Re: District 505 – Tower 10
300 San Mateo Blvd NE
Traffic Circulation Layout
Architect's Stamp 06-06-2022 (K18-D065A)

Based upon the information provided in your submittal received 06-06-2022 and field inspection, the above referenced plan cannot be approved for Building Permit until the following comments are addressed:

C1 CORNER ACCESS RAMP (BASED ON CABQ STANDARD DRAWING #2441-A)

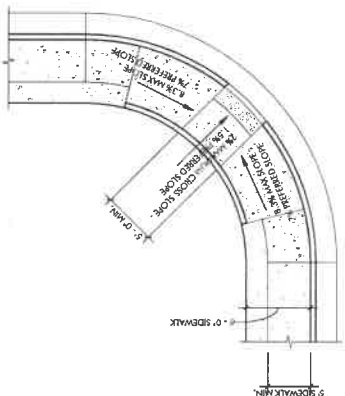
1. Copper/Madeira (Corner Ramp):

- Remove note specifying Contractor to verify Ramp is ADA Compliant. After a field inspection **(Measuring dimensions/taking readings of slope. It was determined the ramp is not ADA compliant within COA public property/ROW).**
- Provide/modify note to remove and replace with the specified COA std dwg shown on plans

D1 DRIVEPAD & SIDEWALK (BASED ON CABQ STANDARD DRAWING #2425B-A)

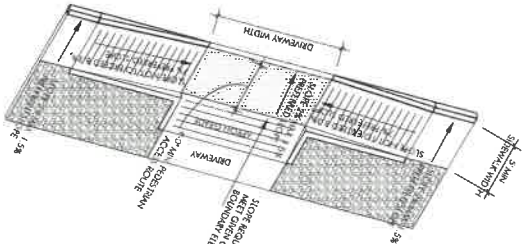
2. Madeira & San Mateo Driveways:

- Remove note specifying Contractor to verify Cross Slope is ADA compliant. **The existing is not ADA compliant after field inspection was determine the driveway transition and pathway are not ADA compliant.**
- Provide/modify note to remove and replace with the specified COA std dwg shown on plans.

E1 ACCESSIBLE PARKING AND RAMP
1/8" = 1'-0"

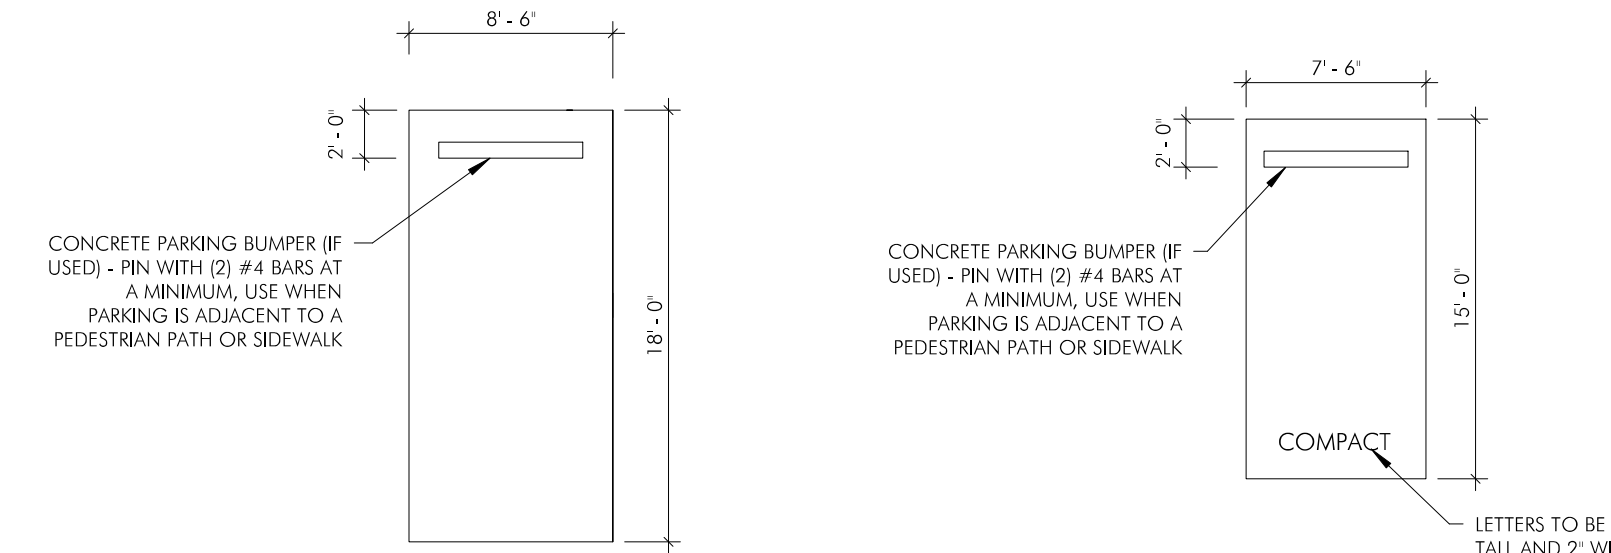
3. Sheet TCL101 (Detail E1):

- **Landing:** Provide text specifying a 50:1 max.
- **Transition/wings:** Show 12:1 **MAX.**
